## Department of Transportation

January 23, 2020

RE: Ellicott Town Center 10.20.19 - CS192\_SF1910\_SF1825

The Colorado Department of Transportation has reviewed for the above mentioned development for Filing No. 1 with 98 residential lots on 288-acres of parks, open spaces, commercial and industrial for the Ellicott Town Center, Final Plat Extension SF1825.

Figure 4  
**2021 Baseline Traffic\*, Lane  
 Geometry, and Traffic Control**  
 Ellicott Town Center Rezone (LSC# 194060)

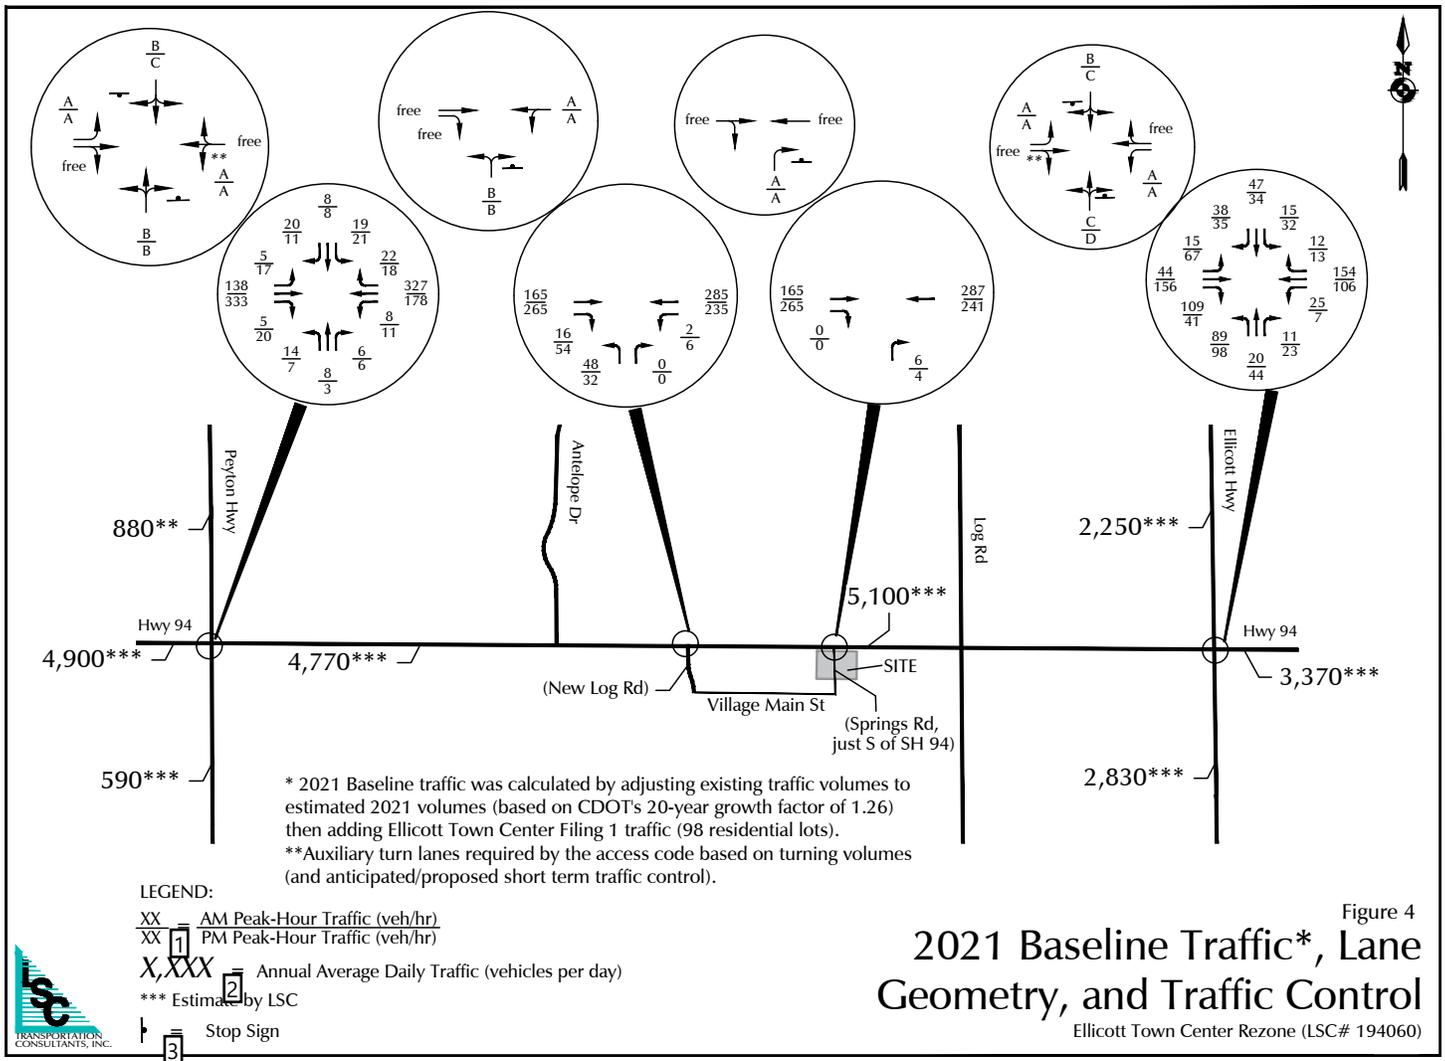
- k. The baseline Synchro reports for Hwy 94 & Peyton Highway intersection has incorrect lane geometry, please adjust.
- l. The developer escrow charts Table 9, 10, 11 are a bit confusing due to some errors within or understanding of detailed information. Resubmit with updates of the TBD should be Filing 2 as a whole and at Hwy 94 & Ellicott Hwy, the developer would be required an escrow amount for the 273-ft eastbound right turn lane of future traffic signal. Please adjust explain and break down will be required as part of revised TIS.
